From: Iqraa Malik
Sent: 25 January 2021
To: Sian Eggington
Subject: FW: Request for further information 17/153/20/HH
Attachments: We sent you safe versions of your files; Clyde Cottage as existing A - 1 to 100 at A3.pdf

202061-01

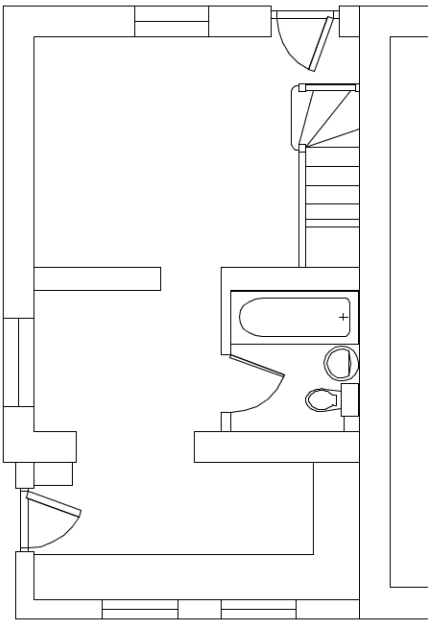
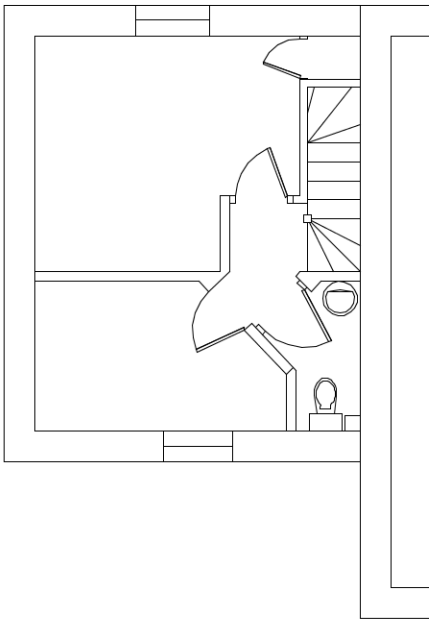
Dear Ms Malik,
Sorry about the confusion, the labelling for the ground and first floors was the wrong way round.
Please see the amended drawing attached.
Regards
Geoff

BLOCK PLAN
SCALE 1:200

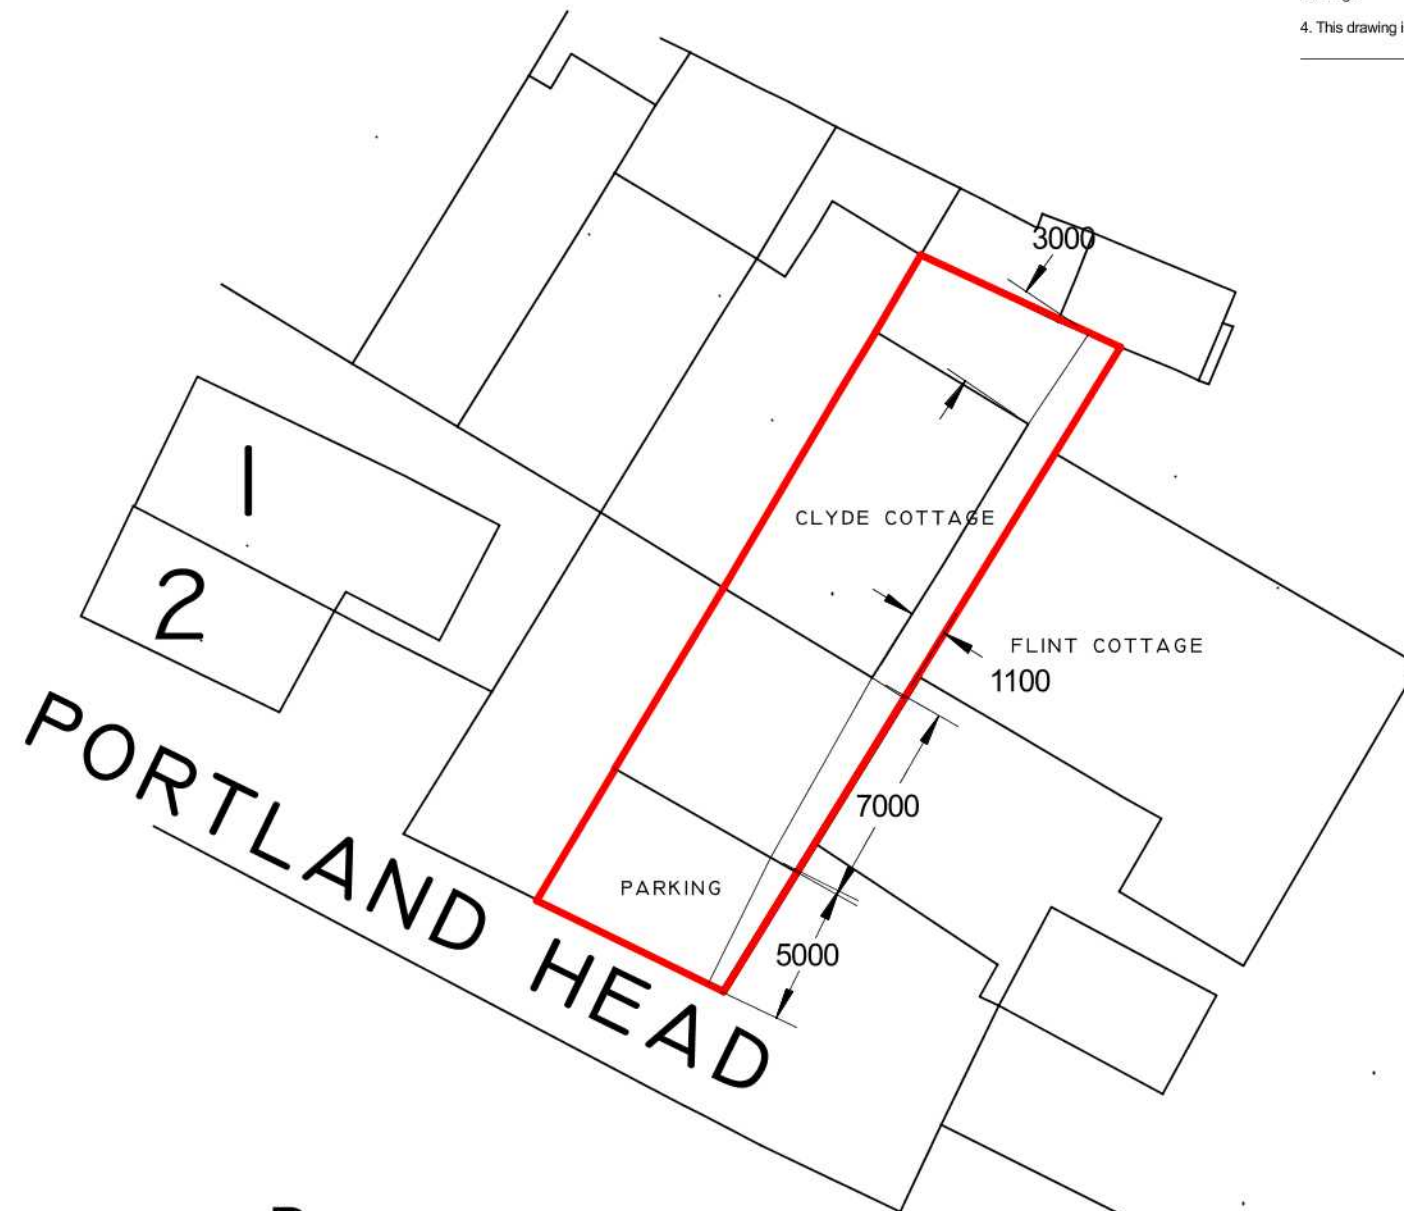
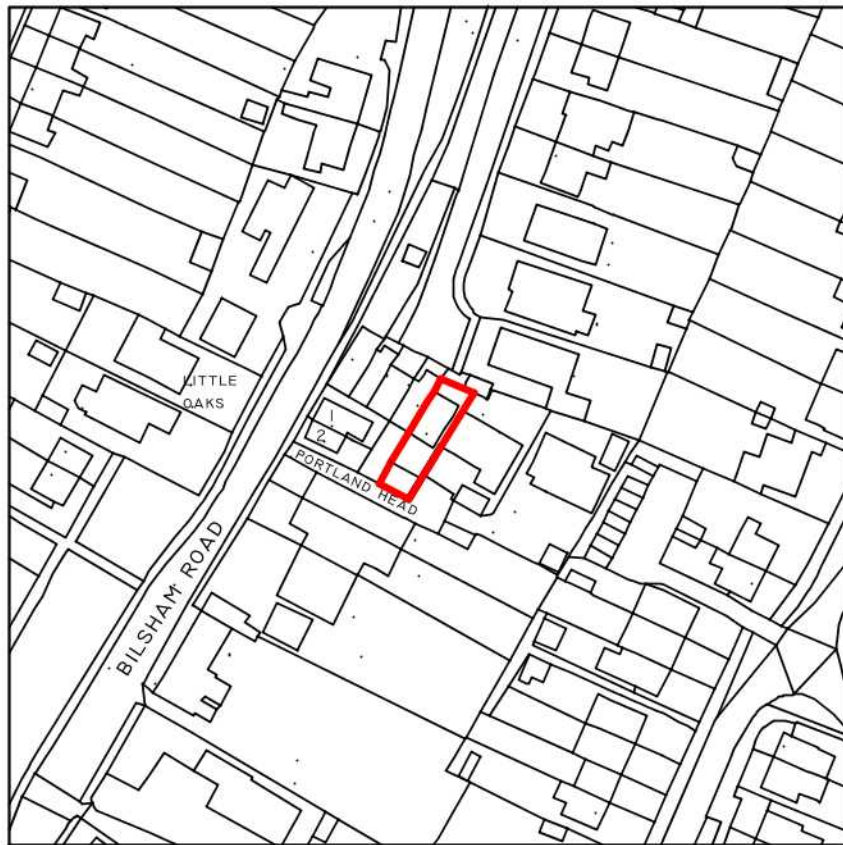
As the plans submitted are showing a ground floor rear extension, this needs showing on the proposed block plan and adding to the description. Please amend.

You are required to provide a proposed block plan with dimensions to all site boundaries. Alternatively, you could add a note to the original plan listing the dimensions to the site boundaries (you won't need to show the proposed extension then)

Arun Council requirements are for a block plan of 1:200 or 1:500.

I have already provided a block plan of 1:200 (Drawing No. 202061-03)

As the application is for a first floor extension, dimensions to site boundaries will be the same.
